From: Harry Chalk
Sent: 06 October 2025 12:27
To: [REDACTED]
Subject: LU/163/25/PL
Attachments: 24890.902 - P2 - Planning - Site Plan (Phase 2).pdf

From: Scott Wilkinson <[REDACTED]>
Sent: 06 October 2025 12:04
To: Harry Chalk <Harry.Chalk@arun.gov.uk>; Katharine Wilkinson <[REDACTED]>
Subject: Re: Acknowledgement for LU/163/25/PL

DRAWING TITLE:
101 - P1 - PROPOSED SITE PLAN
PROJECT NO: **24890** DATE: **DEC 24** SCALE: **1:500 @ A3**

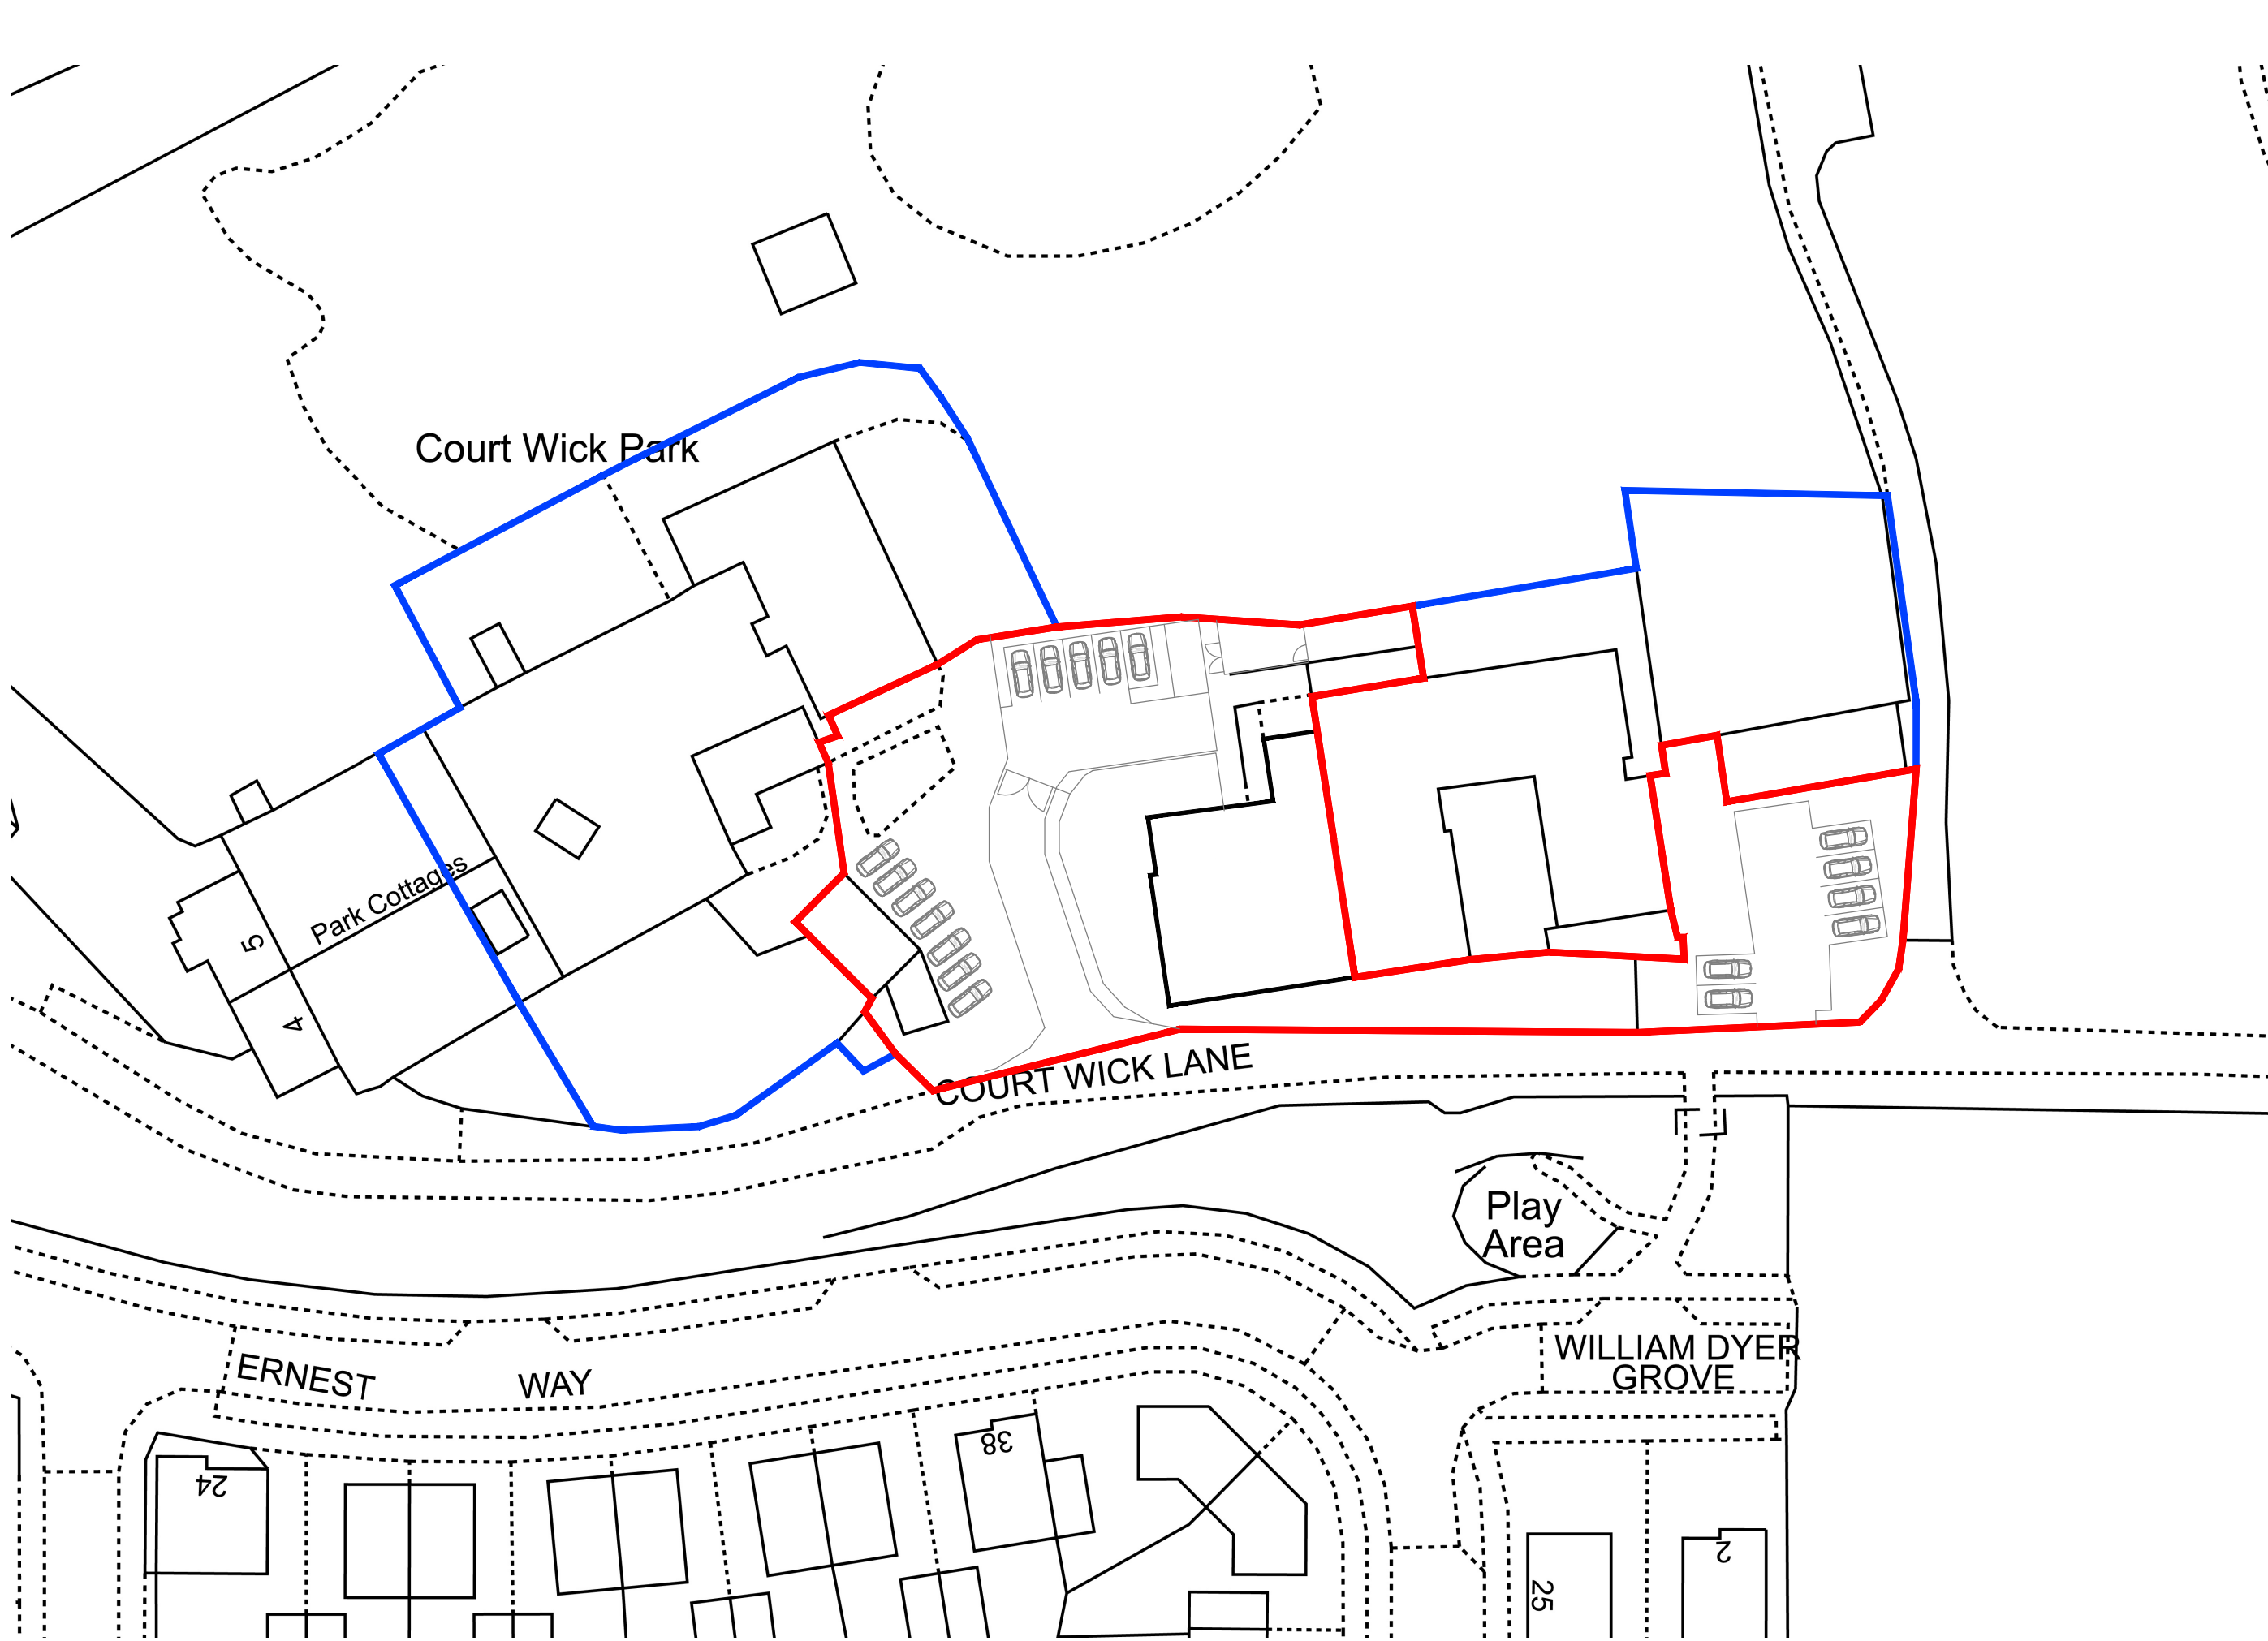
I will need to liaise with the Conservation Officer regarding the alteration of the access route into the Listed Building site to the rear. I am also cognisant that the new access would remove parking from the west of the site which is identified on the proposed site plan 101 - P1.

DRAWING NUMBER / TITLE
902 PLANNING - SITE PLAN (PHASE 2)
PROJECT
STRAWBERRY GROVE, LITTLEHAMPTON

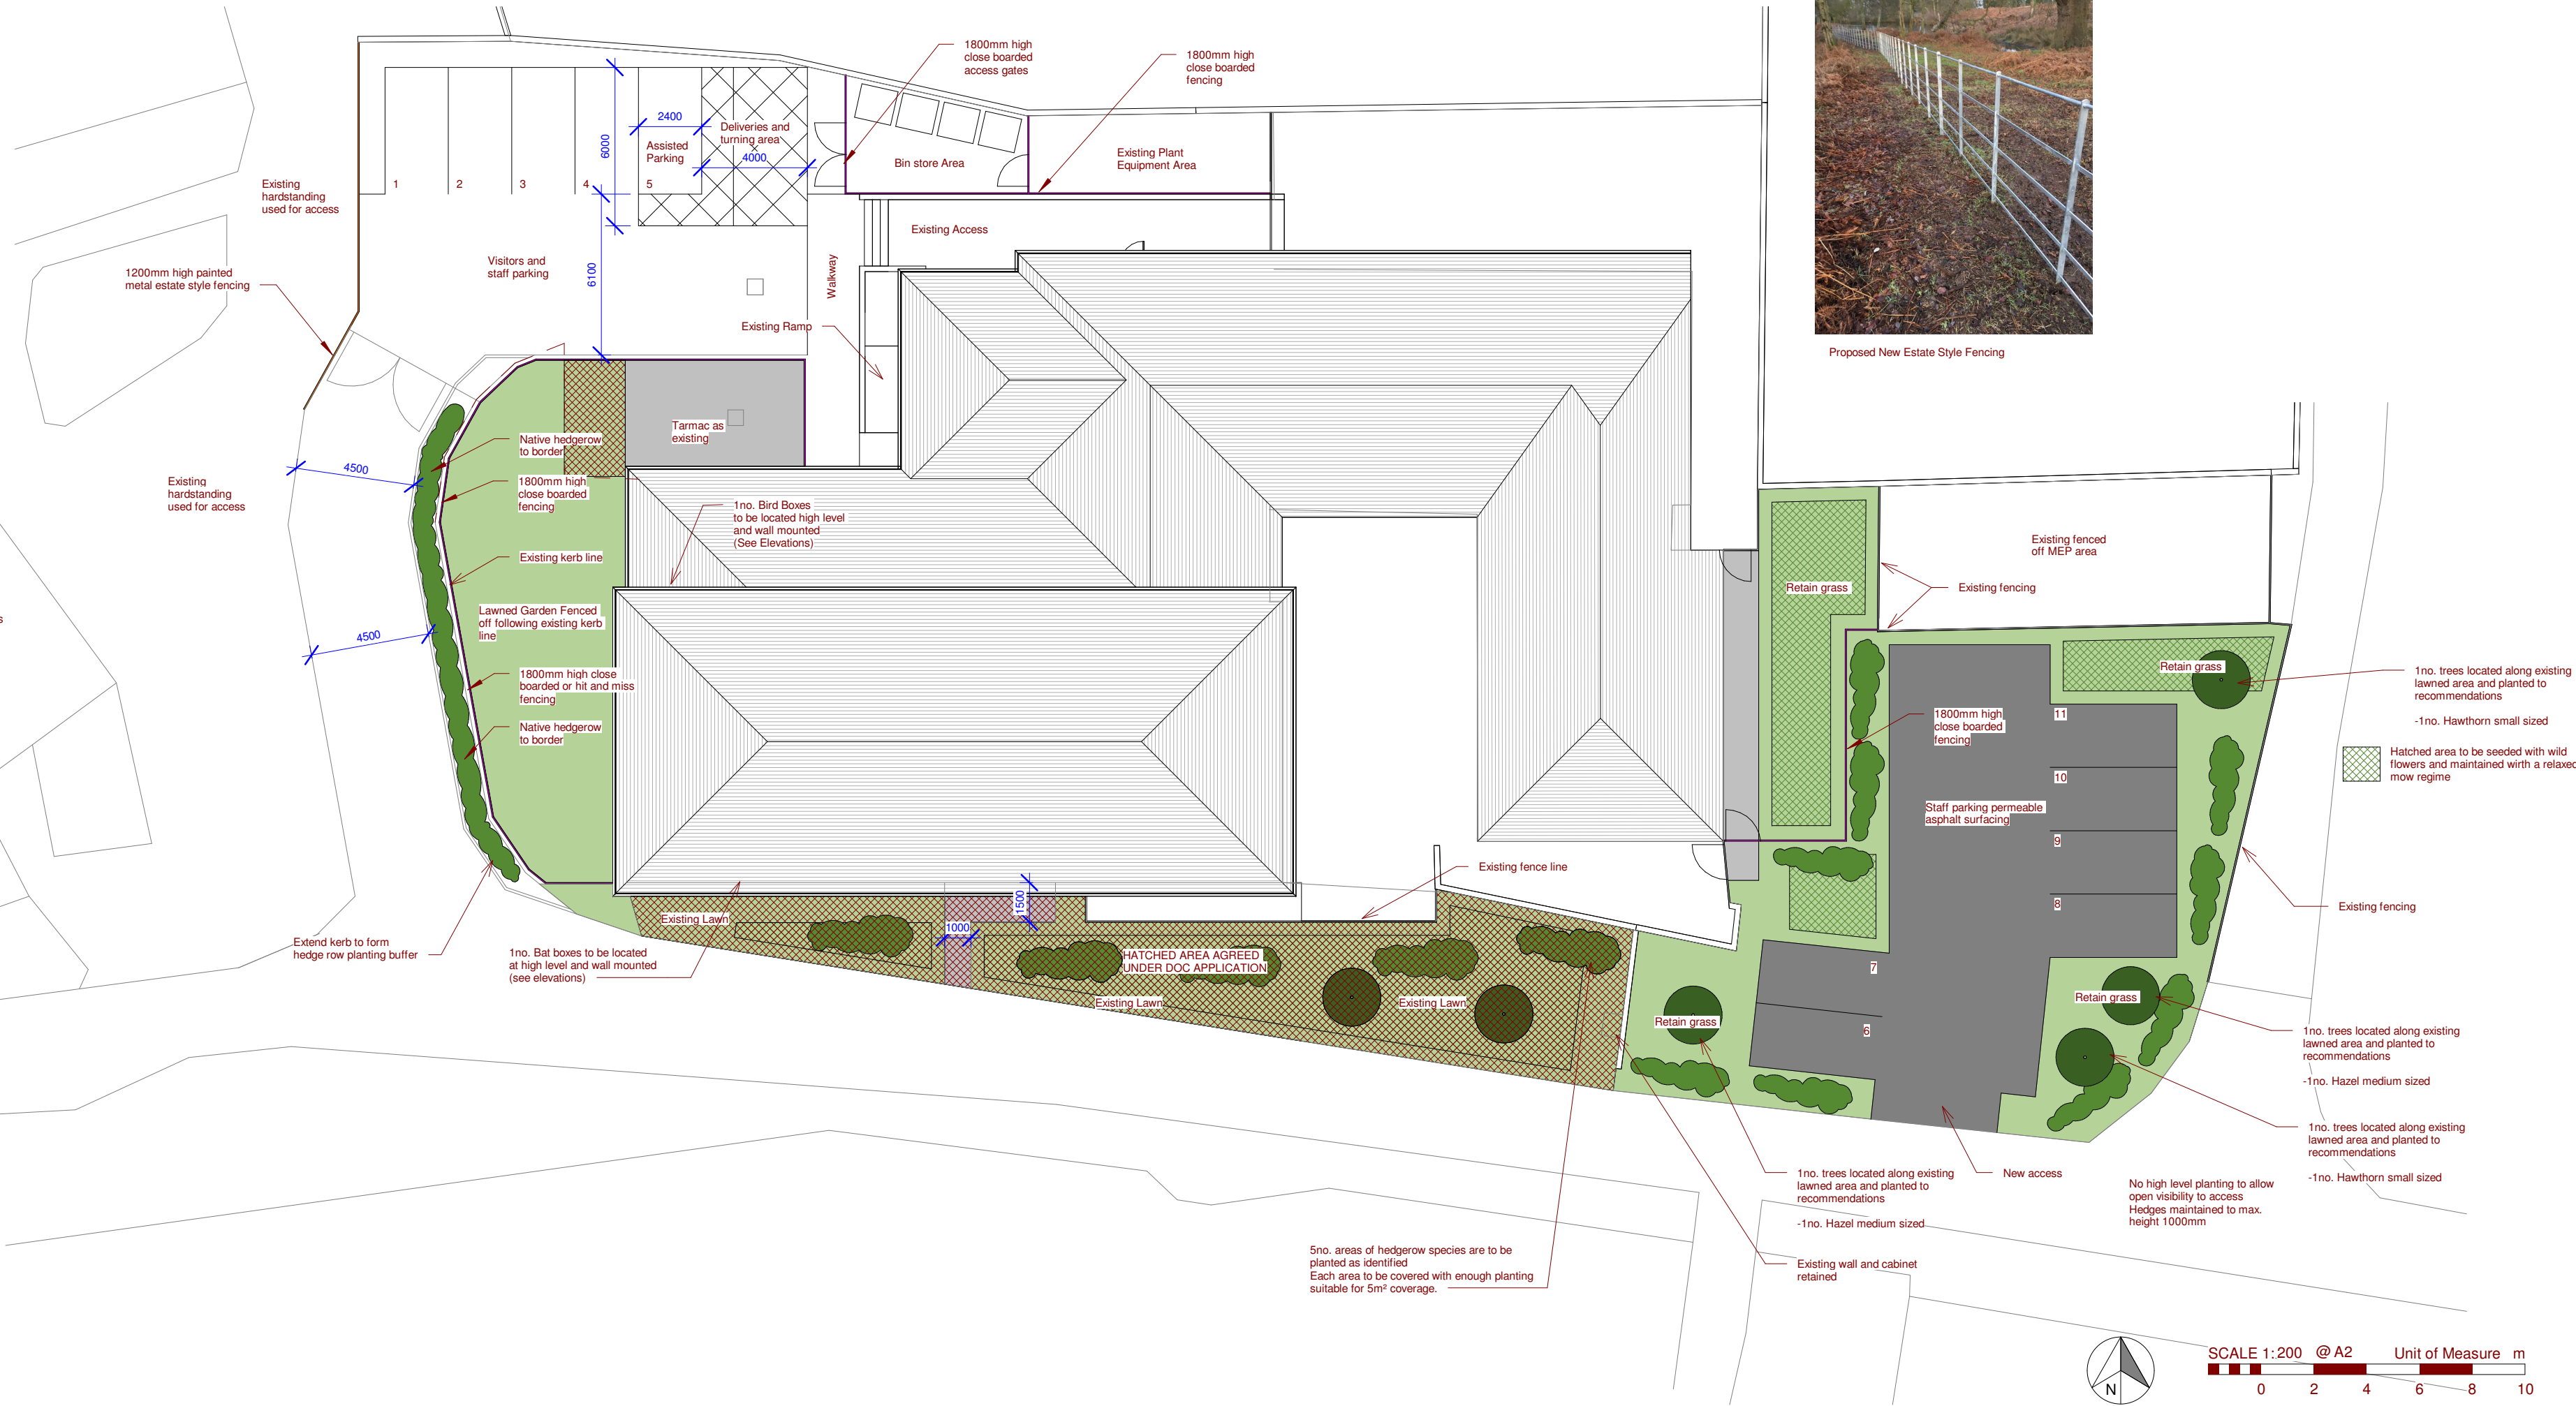
I have discussed this with both Hannah and the Conservation Officer. The aim of removing the estate fencing down the access road was, in part, to reduce the visual clutter within what is currently an open access area, and which would of course be much more constrained following the installation of the close boarded fencing of hedging on the right-hand side, but it was also to seek the omission of the access being split into separate routes.

In reviewing the illustrated hardstanding areas, you have helpfully provided, and the routing you have confirmed, it is clear that this split access would remain. Requiring vehicles to navigate off of the asphalt and onto the brickwork and drive alongside the current asphalt road before then driving back onto the asphalt would be unintuitive. I also can't quite picture how the parking arrangements shown on the submitted site plan would remain for Courtwick with this routing. It does seem they would be heavily reduced/prejudiced by such a routing.

I do feel there would be a simple solution to this and would be happy to discuss the matter if you are available. It would involve retaining the existing asphalt road as an access for both units, but it would still allow the proposals to remain broadly as submitted while preserving the illustrated parking (see below). I believe it would resolve this concern for myself and the Conservation Officer.

I think we will need the site layout plan updated in illustrate this in detail. Could this be arranged?

The reason I ask is because annotations on the plans say existing hardstanding to be retained, but from review of the plans themselves this is unclear. I am trying to understand the Site Plan Phase 2 layout around the access. Forgive the crude drawing below but I would find it difficult to write out an explanation without it.

If you see below, the green arrow demarks the access into the site, making use of the existing access road.

The overlain red line follows a grey line that I assume is the boarder of the brickwork hardstanding to the west that serves as parking. But this appears inaccurate on the plans compared to on site.

The amber arrow is what I would expect the vehicular access to the listed building at the rear to be, maintaining use of the existing access road. But based on the red line, the estate fencing would result in the need for cars to veer around the fencing onto the brickwork before coming back onto the access road and continuing. On site, I do not believe the edge of the brickwork follows the line shown on the plans. So, the line appears inaccurate. Could this be checked and it be ensured that there would be adequate space between the end of the estate fencing and planting/brickwork parking area to the west of it?

Could you confirm whether there are any alterations proposed to the surfacing of the car park proposed to reflect the two distinct routes now proposed?

Thanks for the chat. As discussed attached is the updated drawing. Hopefully this covers the concerns.

The access to Courtwick would be treated as separate.

The layout was discussed between Hannah and the Conservation officer at the time. They were happy with this proposal then and she did offer to discuss this with the appointed case officer when this resubmission went in. (we have just been waiting for the BNG assessment before putting it back in). We have limited the amount of estate fencing along the access however we could extend this all the way to the road.

With regards to the Parking. The parking on the block paving is for the Courtwick site and would remain as existing.

Happy to explain, so the applicants intention is to retain the existing hardstanding (inc. the brick pavers), the brick pavers will act as the driveway access for Courtwick and the tarmac area would act as the driveway for strawberry.

There will be an adjust mean to the surfacing in that the planting to the East is being installed with new kerb edging. A pin kerb detail will then define the 4500mm along the Western side of the 4500mm wide access road. The estate fencing will only start by the access gates to the strawberry site.
